From: Roger Frost [ferring-pc@btconnect.com]
Sent: 04 June 2008 08:50
To: Planning.Responses
Cc: Bryan McCansh
Subject: Re: Planning Consultation on: FG/69/08/

OBJECTION - FG/69/08 - 34 Elm Park

DRAWING NUMBER 14408.1A.

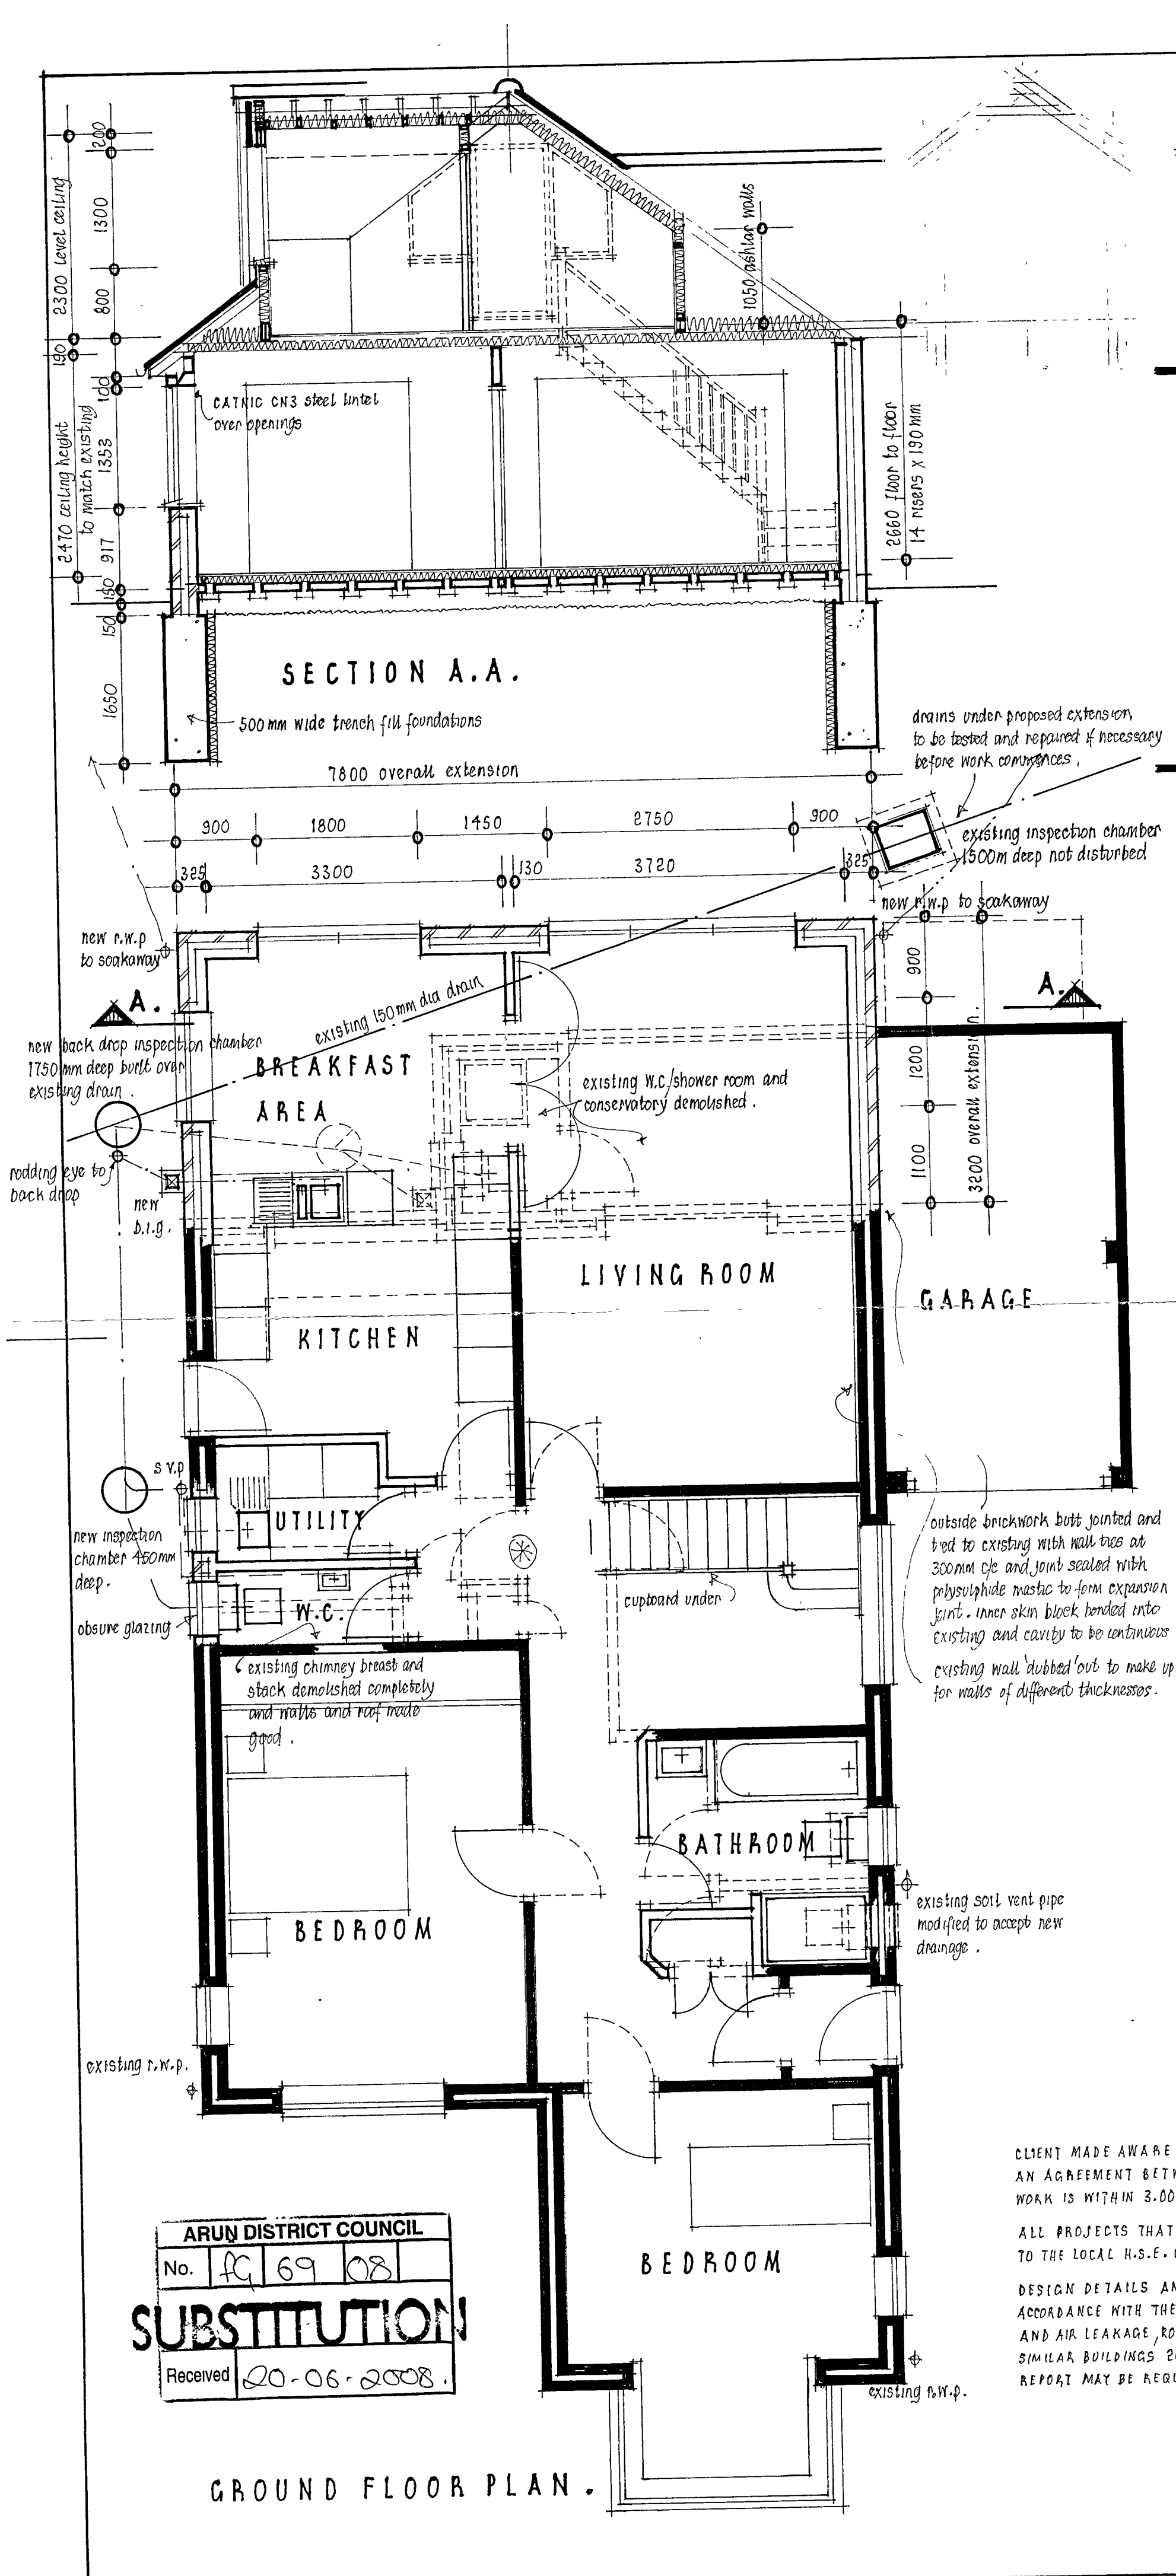
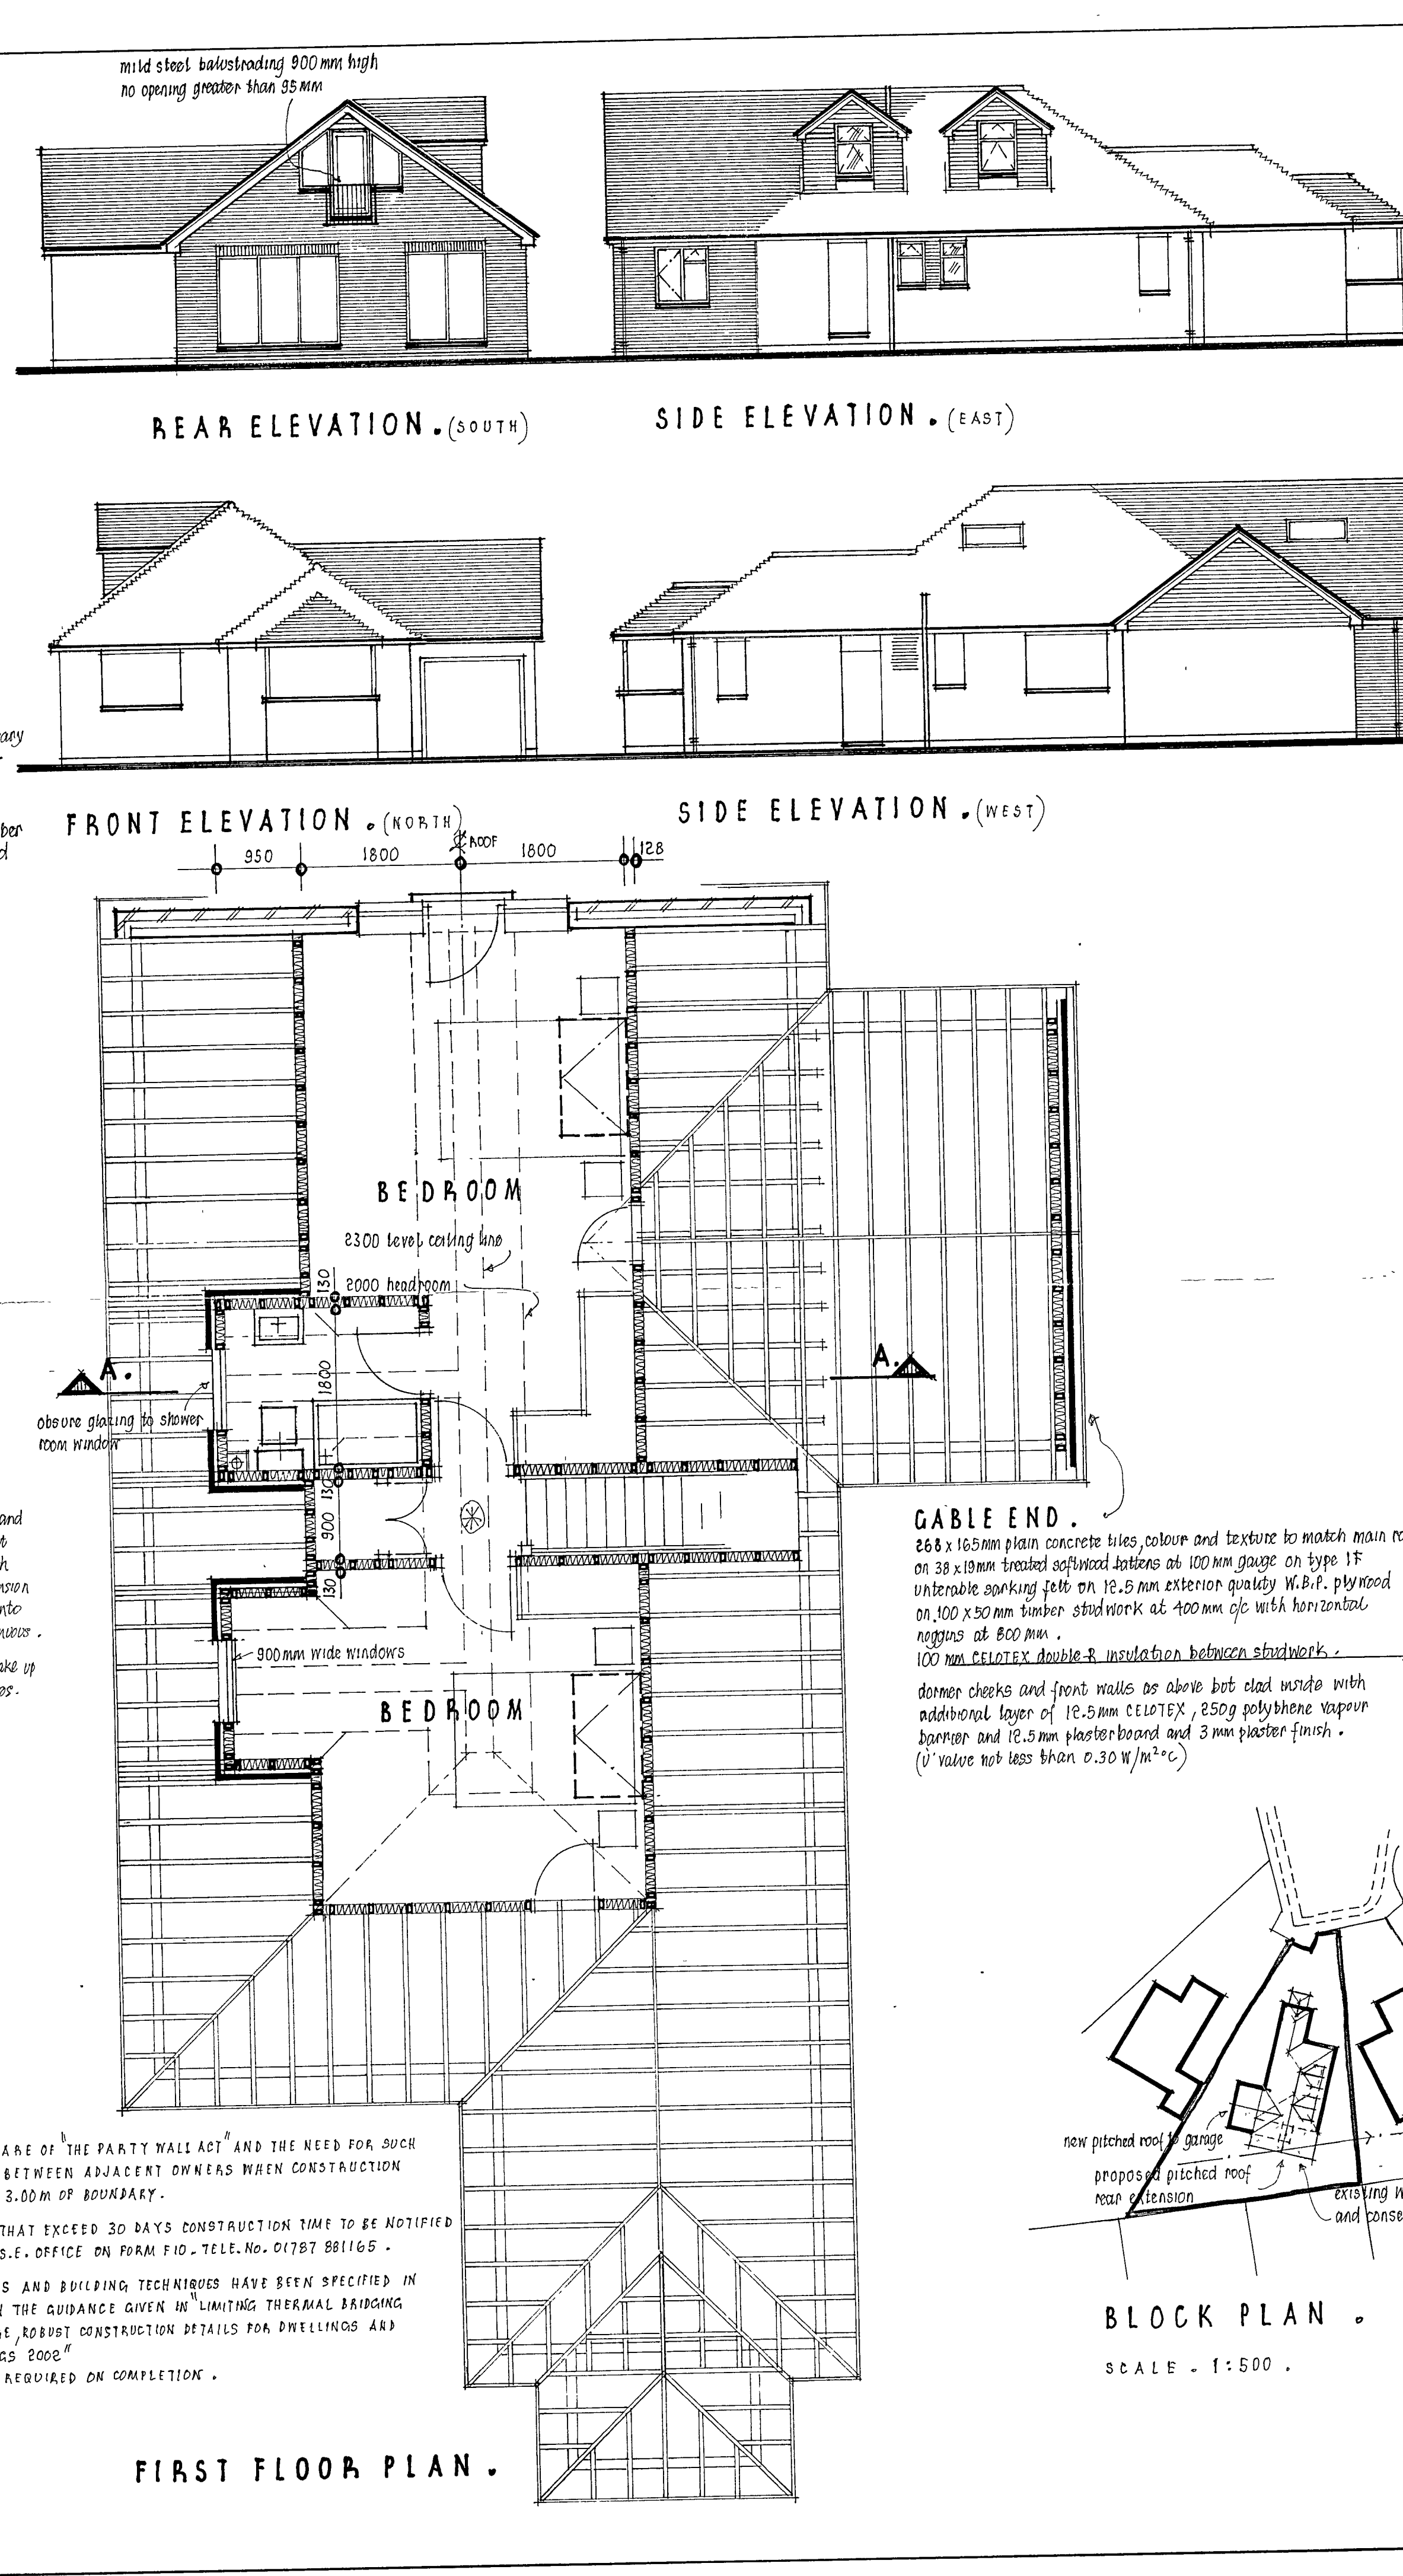
The three dormer windows on the side elevation overlook the house and garden of the adjoining property which does not accord with the provisions of GEN 7 (iv).
The Parish Council wishes to raise strong objection to this development.
